Date: 11 November 2022  
Our ref: 409224  
Your ref: EN010106

**NSIP Reference Name / Code: Sunnica Energy Farm EN010106**  
**User Code: 20031393**

**Written Representations and response to the Examining Authority's first written questions**

Drawing Title
**FIGURE 10-14E
LANDSCAPE MASTERPLAN
SUNNICA WEST SITE B**

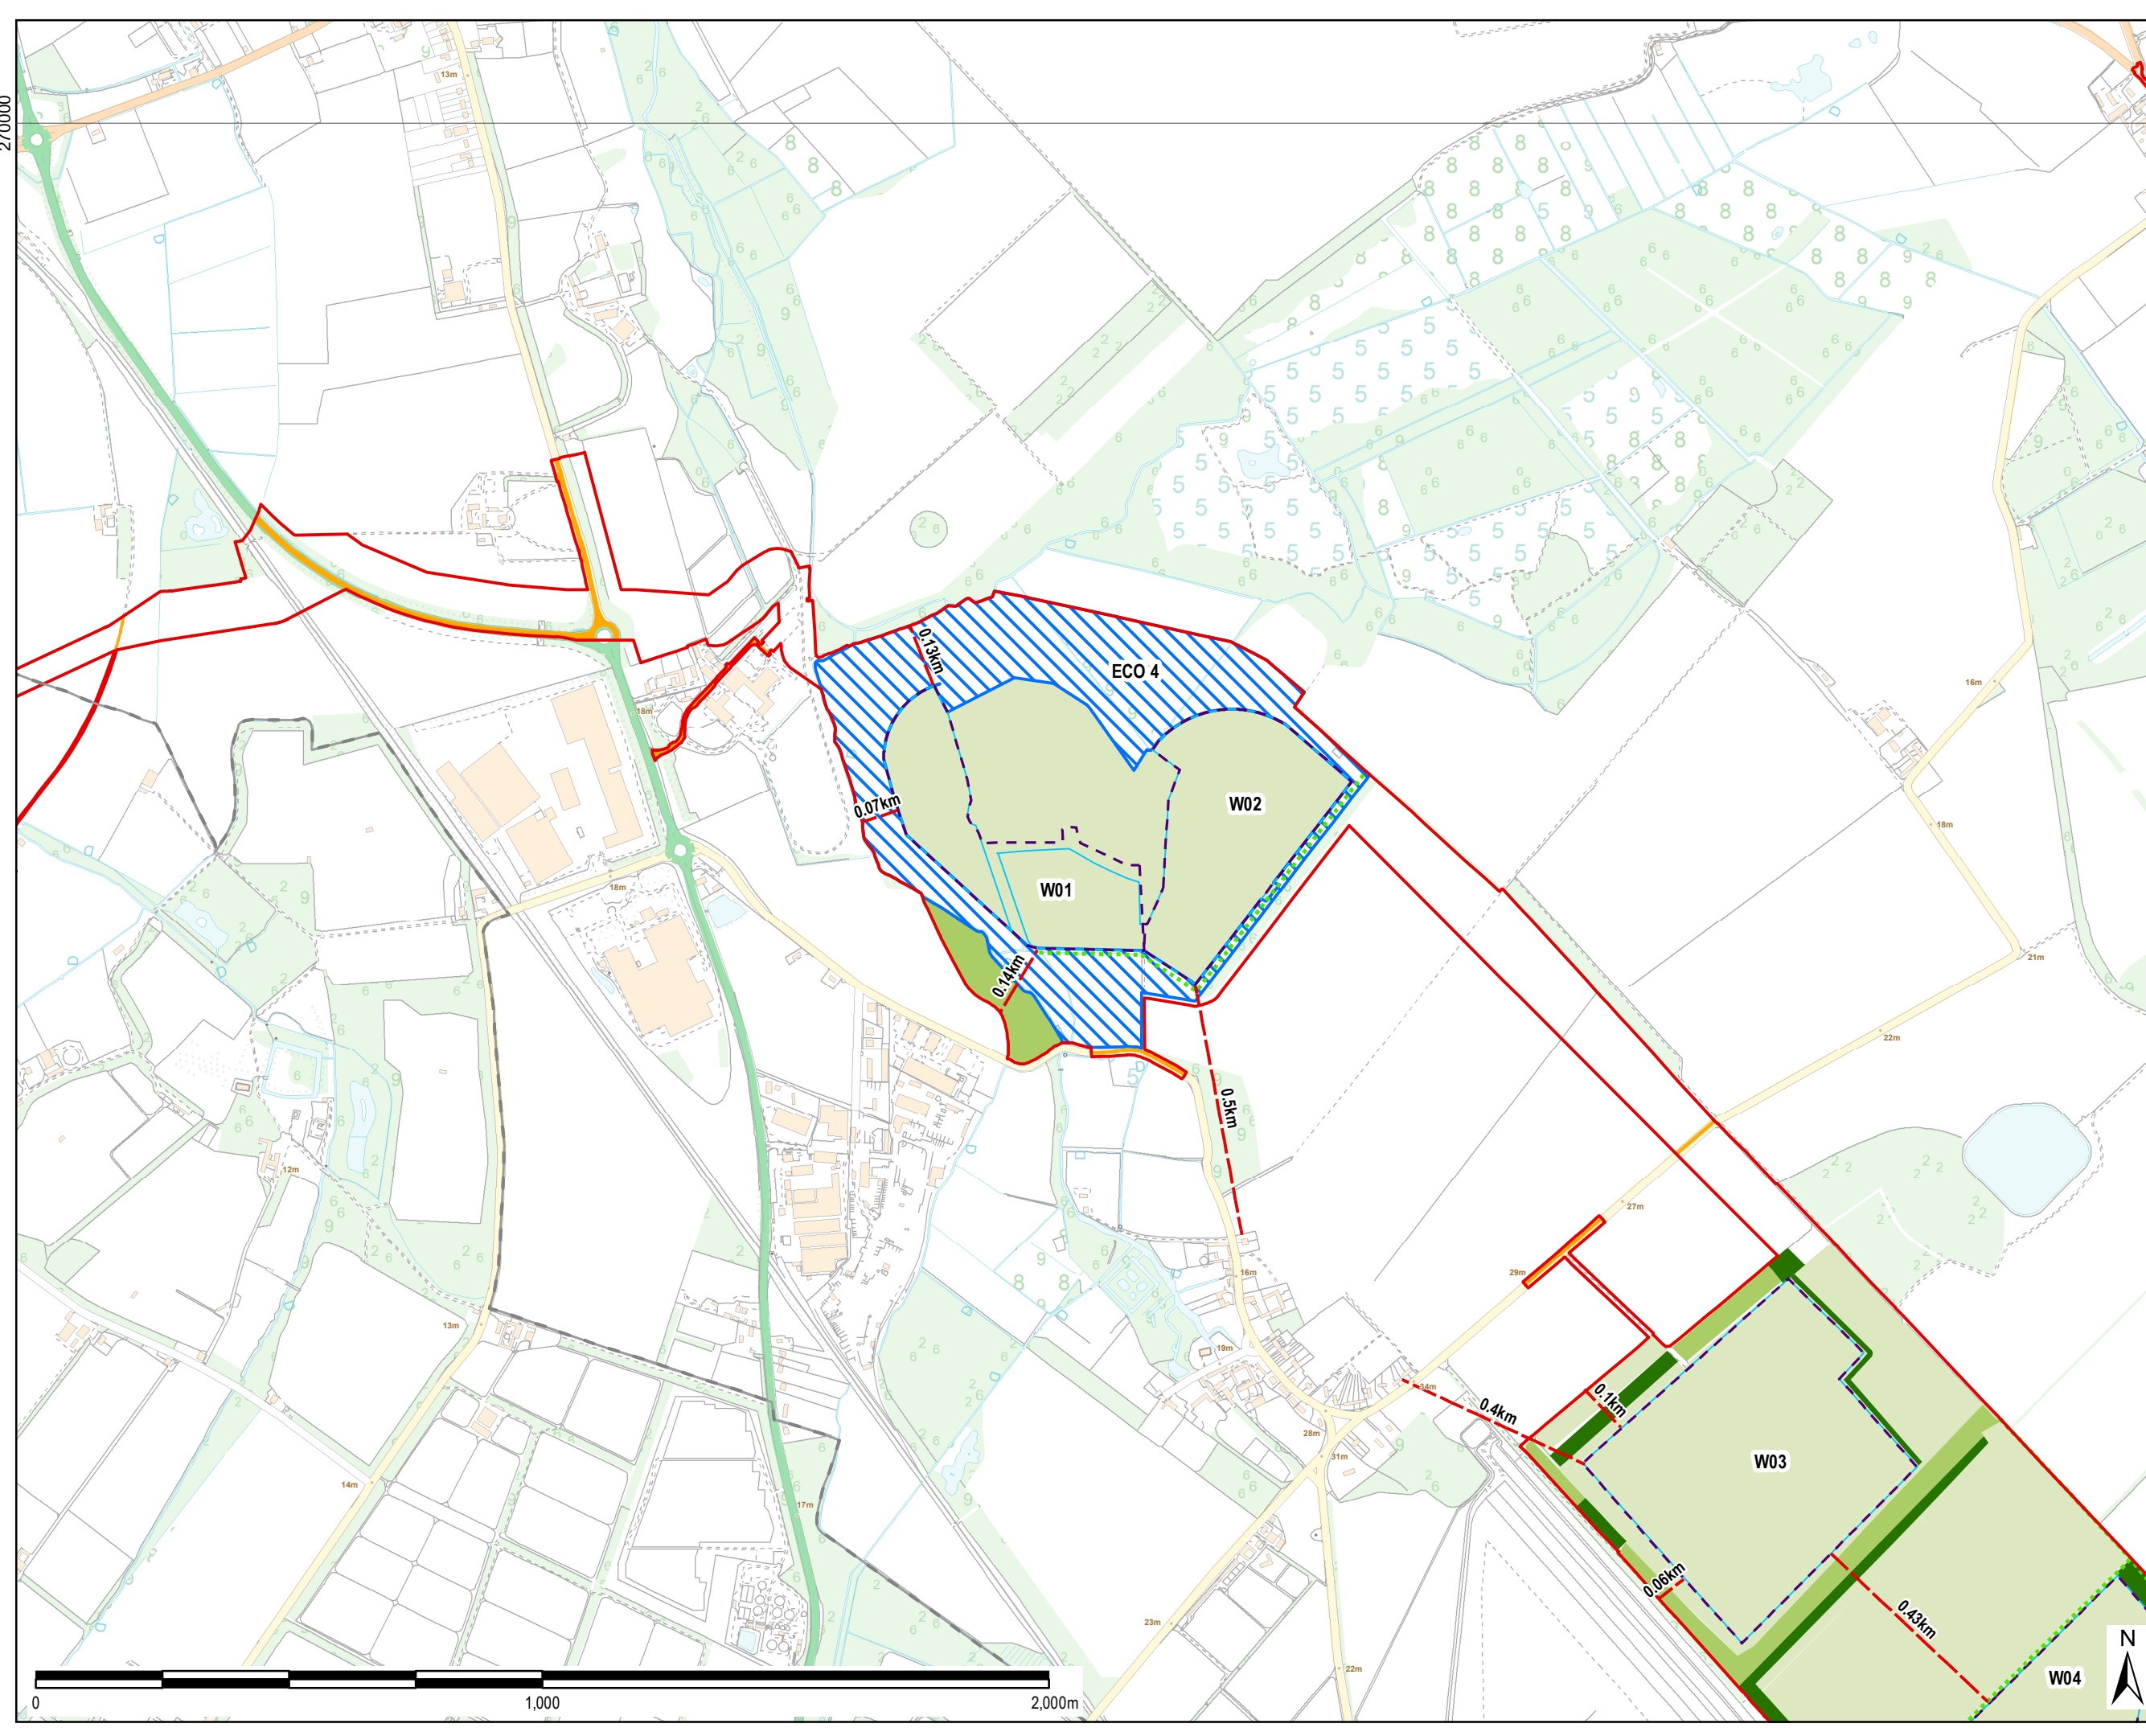
Q1.2.9	The Applicant and Natural England	<p><b>Ecological mitigation</b></p> <p>How confident are you that new wetland indicated in Figure 10-14E of the Environmental Statement,</p>	<p>Natural England does not currently consider that there is enough information given to comment on the likely success or</p>

Landscape Masterplan [APP-213] can successfully be created, in ecological and operational terms?	<p>failure of creating the wetland. We would require further information such as:</p> <ul style="list-style-type: none"> <li>• Existing water levels in the area</li> <li>• Are the soils in that area 'wetland type' I.e. is there a history of it being wetland</li> <li>• Are the fields currently being drained and if so what are the plans to address this?</li> <li>• How will the water levels and the resultant wetland be managed?</li> <li>• Will a seed mix be used or will natural regeneration be used?</li> </ul>
Q1.2.12	Natural England & Suffolk Wildlife Trust	<b>Grassland re-establishment</b> ref [APP-101] Do you consider the Applicant's proposal to secure locally harvested seed to be appropriate and achievable?	Harvesting local seed is a standard approach that is regularly used in habitat creation. Natural England has no particular concerns at this stage.
